Our Ref: AL/76/19/PL
Your Ref:

Town & Country Planning Act 1990 (as amended)
Town and Country Planning (Development Management Procedure) (England) Order 2015
Application for Planning Permission

Development Demolition of existing dwelling & erection of 3 bed replacement chalet dwelling
Location Evergreens Level Mare Lane Fontwell

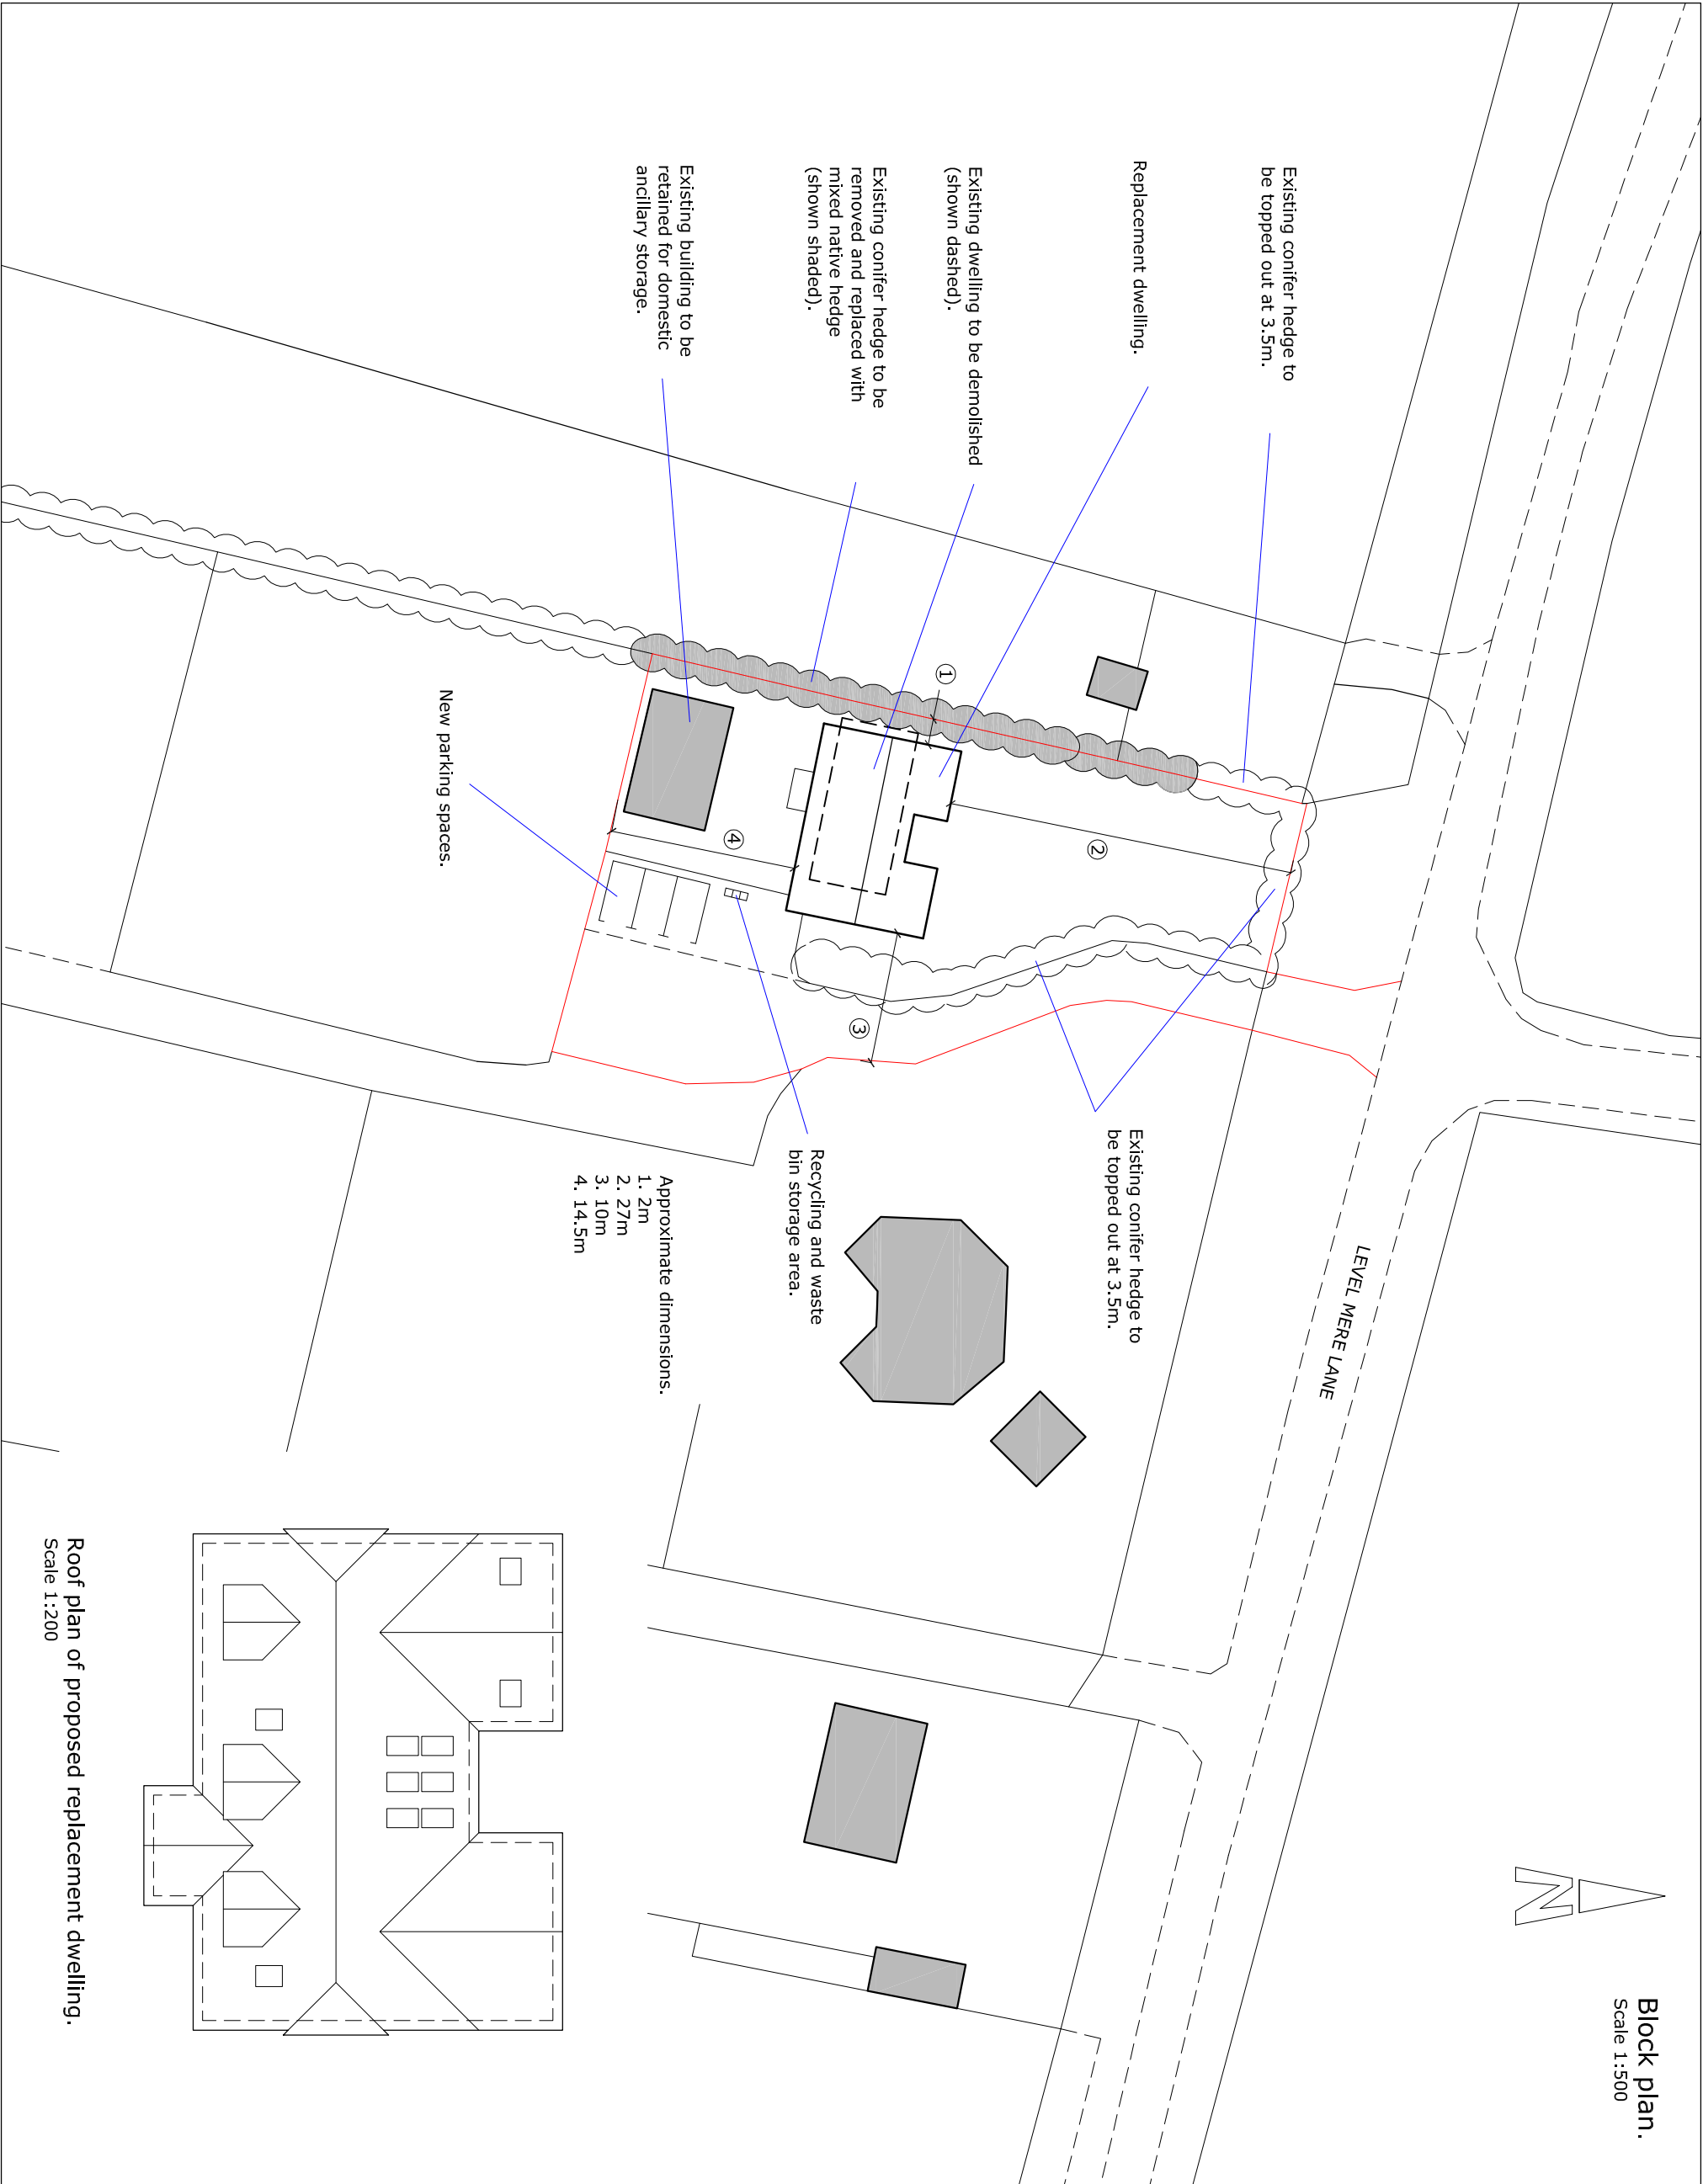
Block Plan Amend

Please provide dimensions from the proposal to the site boundaries and show the position of the rubbish/recycling bins.
